# MDDP AMENDMENT & FINAL DRAINAGE REPORT

## MERIDIAN ROAD & BENT GRASS MEADOWS DRIVE

El Paso County, Colorado

#### Engineering Review

MERIDIAN ROAD DRAINAGE PLAN

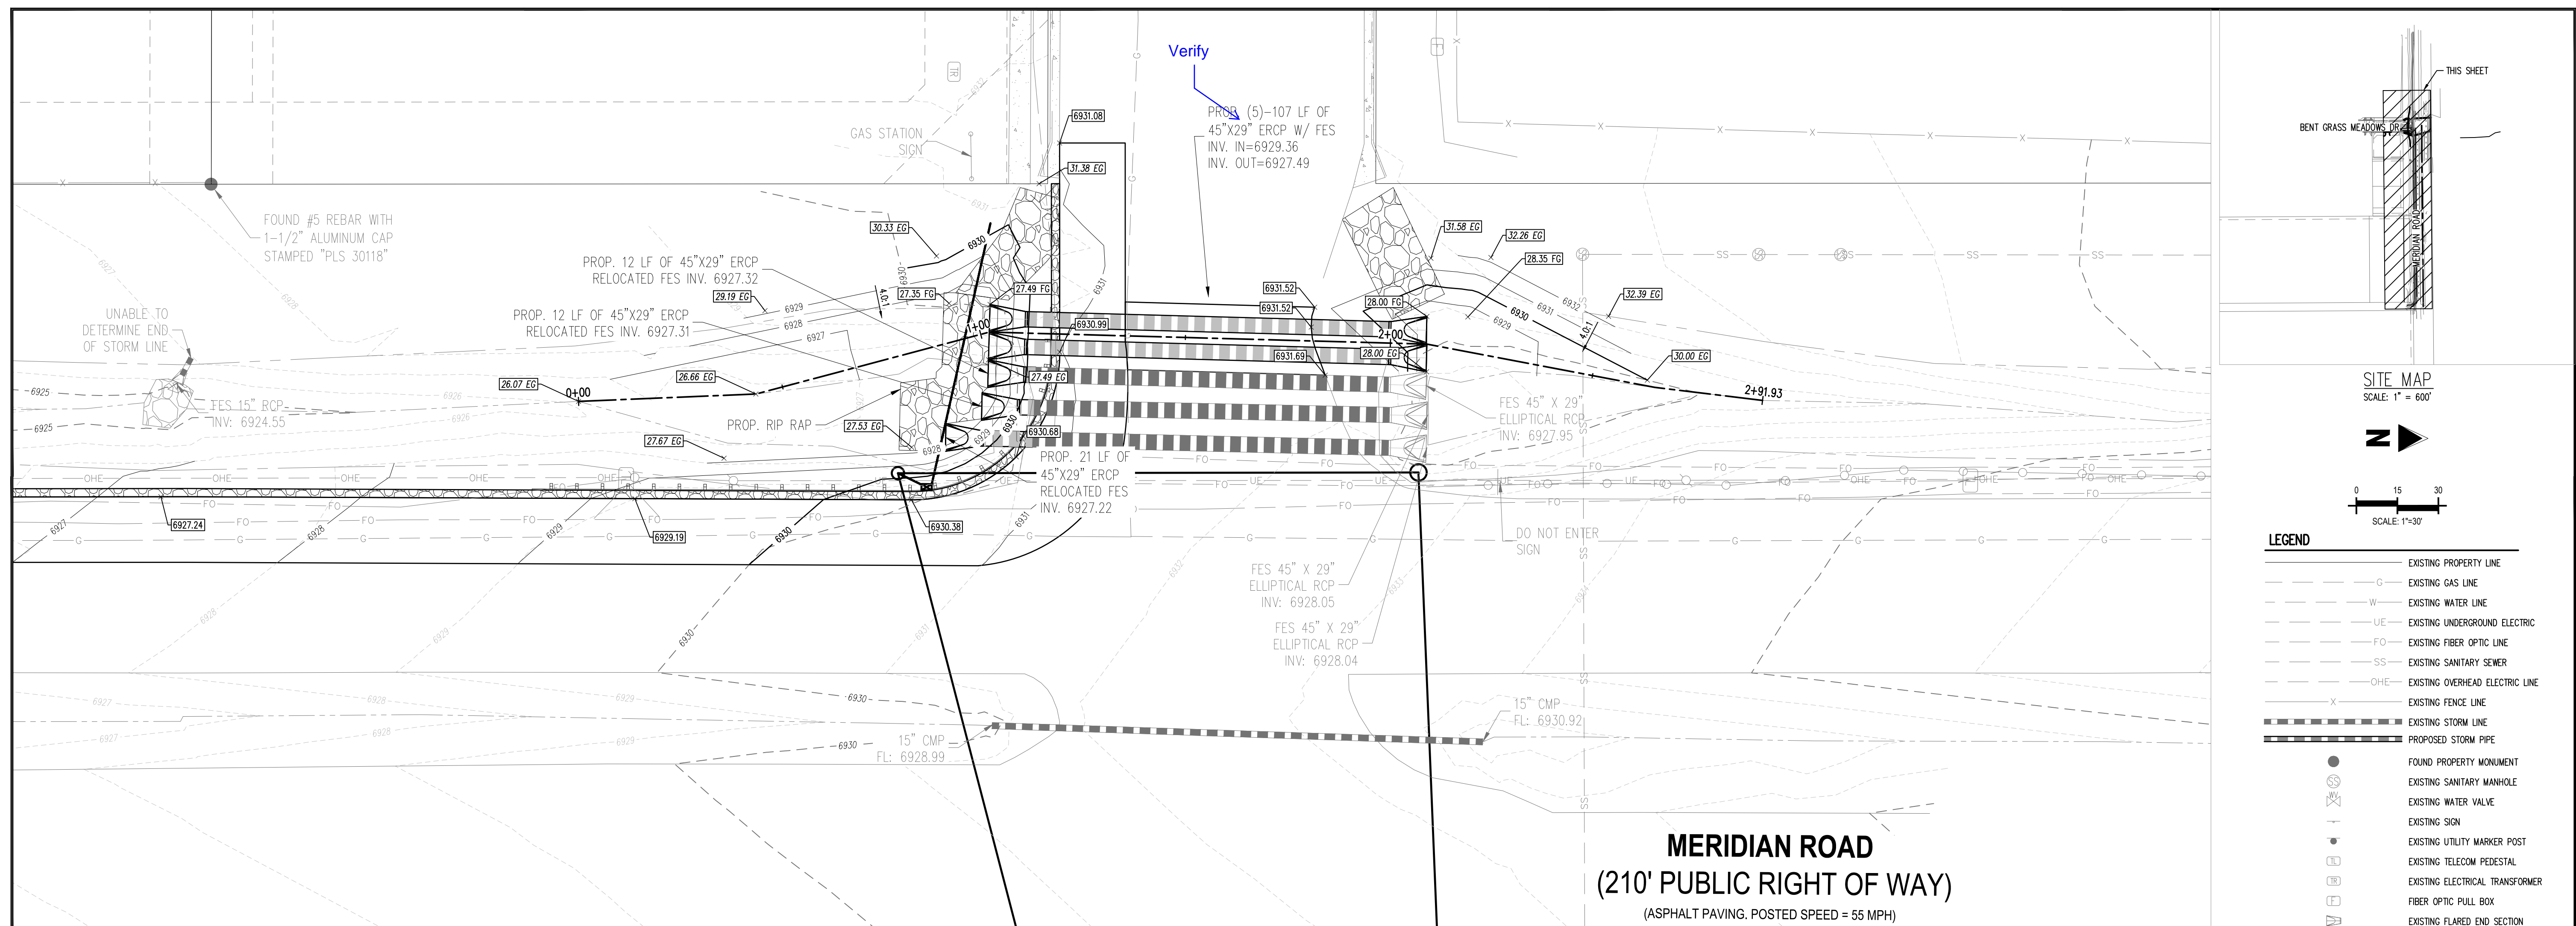
Address here or with DP15 the channel or pipe necessary (size of both options) to convey existing flows outside of Bent Grass Meadows Drive.

Provide options for a long-term solution -- the channel or pipe necessary (size of both options) to convey developed flows outside of Bent Grass Meadows Drive. If water rights allow for retention of flows, describe. State what the allowable capacity of Bent Grass Meadows Drive curb and gutter is along the north side (no overtopping unless it can be shown that flows won't enter the subdivision to the south).

Verify capacity for the total diverted flows.

"offsite" items will be addressed with MDDP/DBPS report. Statement has been added to this report stating as such.
